**CITY OF ALBUQUERQUE  
PLANNING DEPARTMENT  
September 25, 2013  
DRB Comments**

**PROJECT # 1009835**

**APPLICATION # 12-70683**

**RE: Lots 37 - 41, Block 8, Palisades Addition**

**PLAT OF
LOT 41-A, BLOCK 8
PALISADES ADDITION**

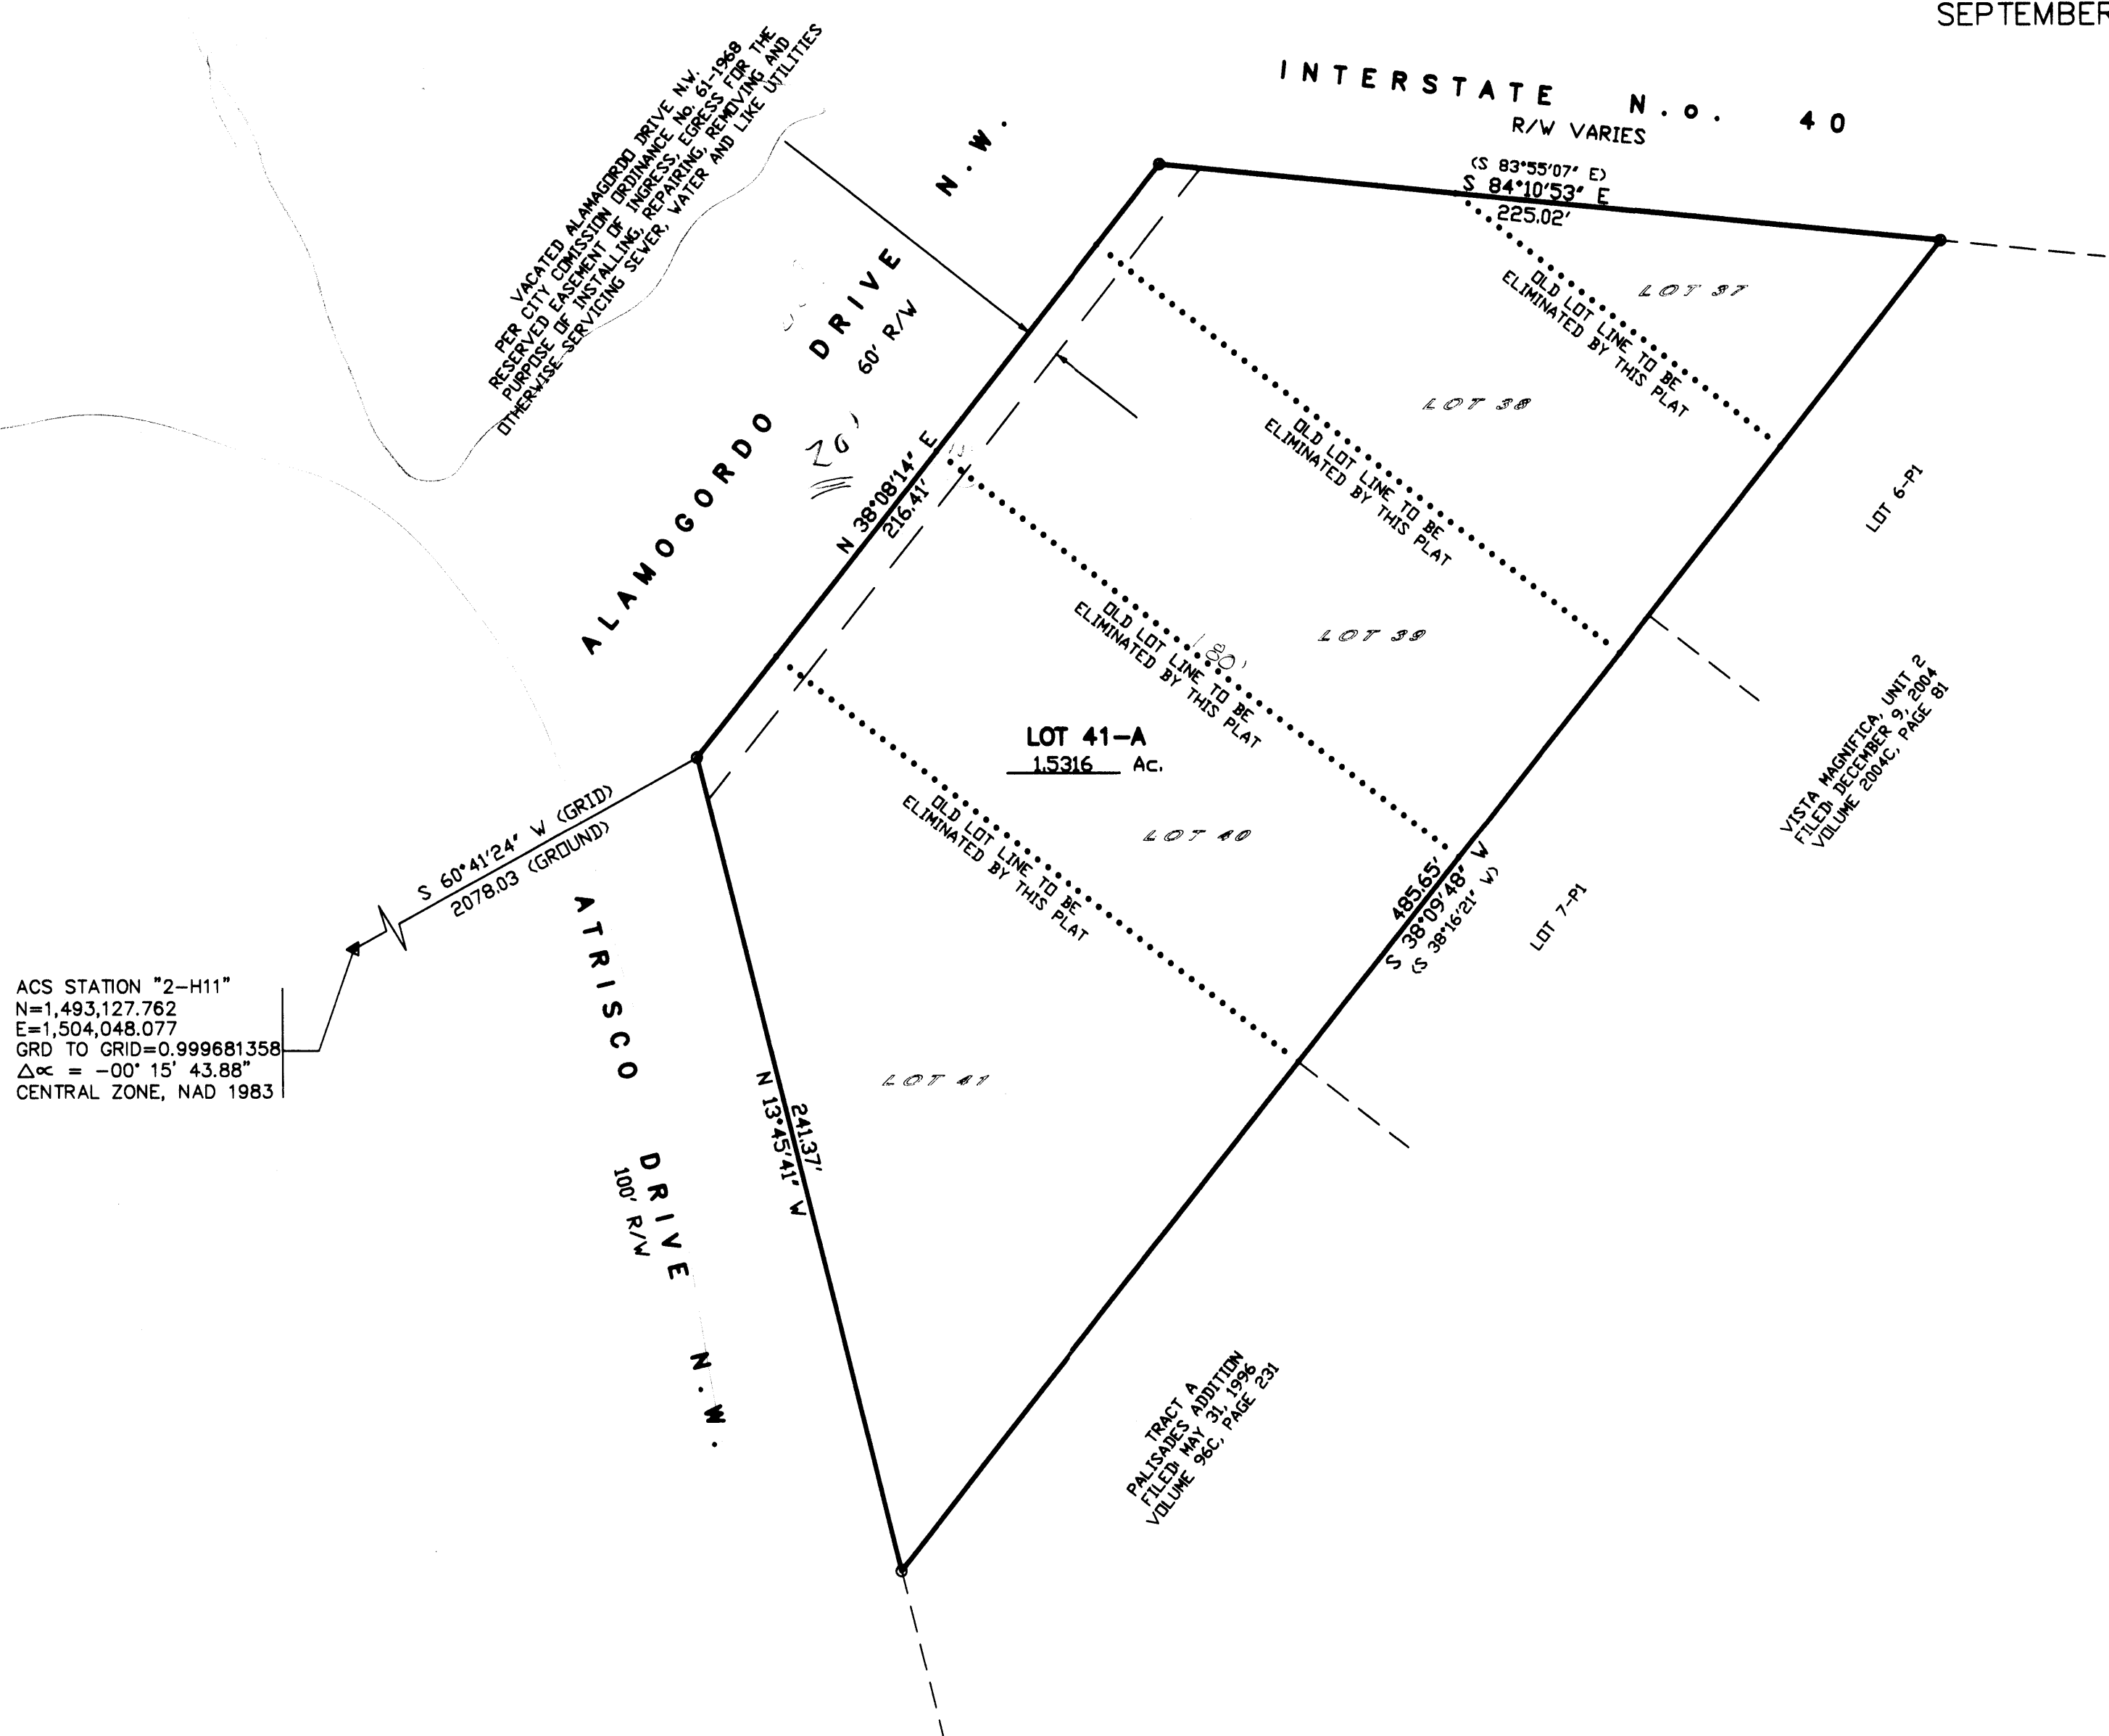
A copy of the Vacation Ordinance 61-1968 needs to be provided for the file, and Property Management needs to sign off on the plat for final approval. It appears infrastructure may be required if right of way is remaining for Alamagordo.
